Mrs R E Goddard
Oldbury Farm
Marsh Lane
Easthampnett
West Sussex
Chichester
PO18 0JW

1 May 2017

**Objection to the Discharge of Conditions on the “Nyton Stables “
development, (AL/23/17/DOC)**

Tree and Hedge Planting

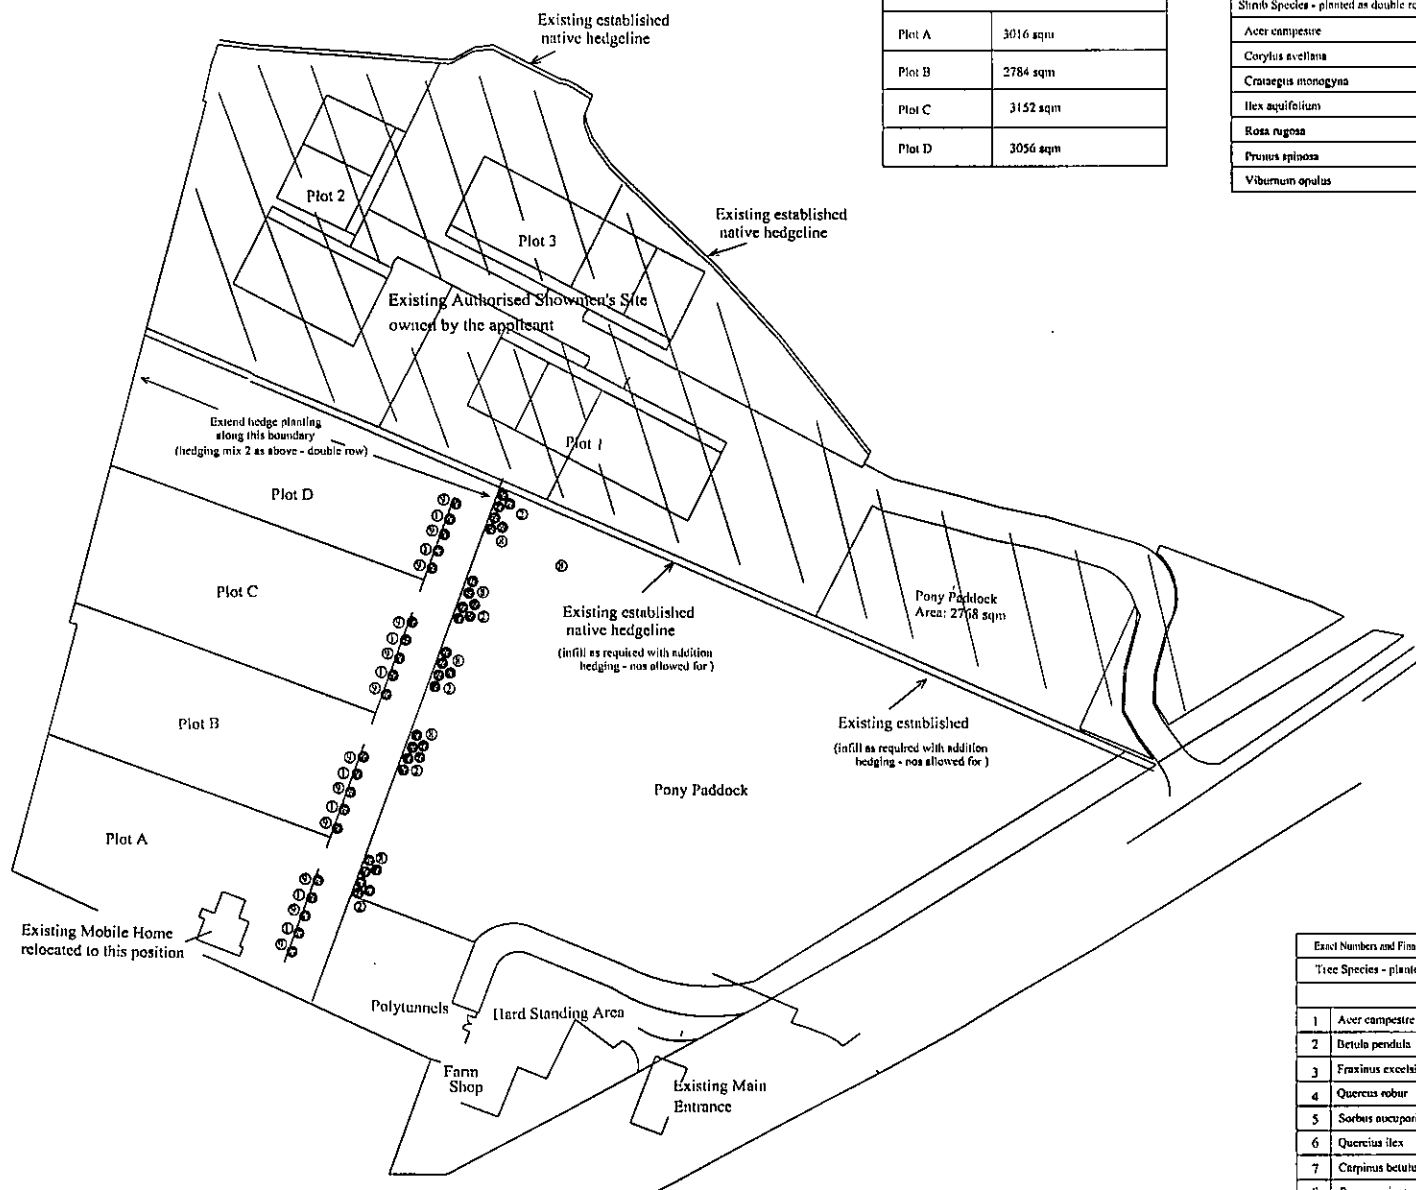
Over the past year, we have endured from this development blazing column lights and associated domestic lighting, penetrating the night where before there was darkness, and this has been a serious intrusion on the lives of ourselves and our neighbors in Marsh Lane. We have a complaint being dealt with at the moment regarding this, and the lack of adequate boundary landscaping that might afford us some protection.
